CITY OF ALBUQUERQUE

February 7, 2017

Re: Rio Grande Inn Storage Addition
Traffic Circulation Layout – Not Required
Architect's Stamp dated 12-22-16 (H13-D107)

SITE PLAN
A1.1 1" = 20'-0"

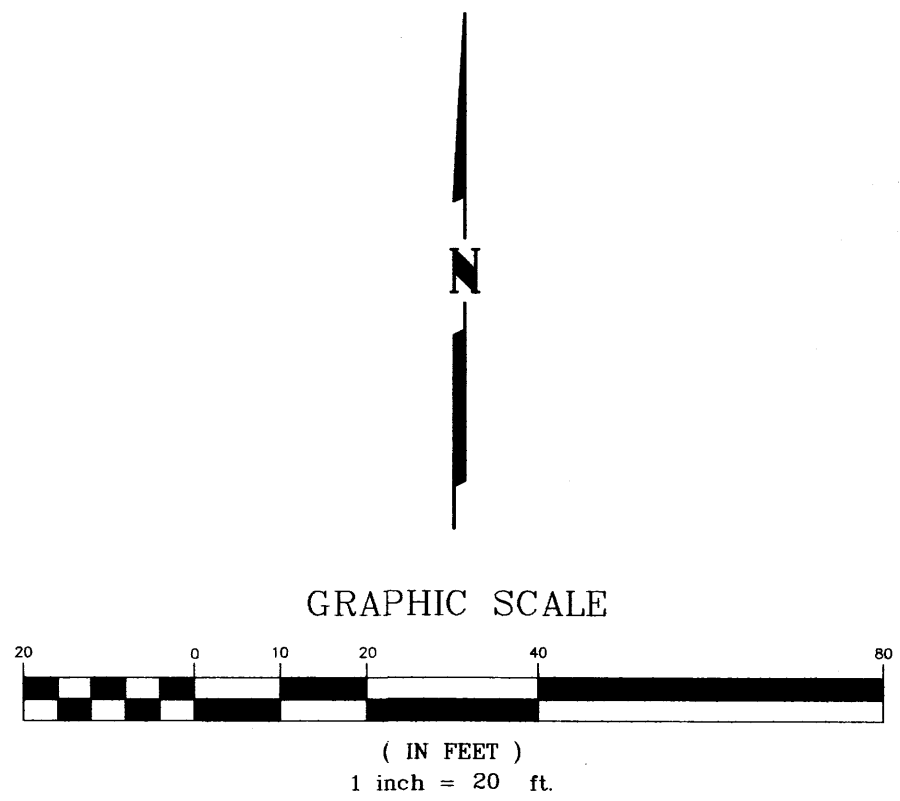
1. Label the compact parking spaces by placing the words "**COMPACT**" on the pavement of each space.
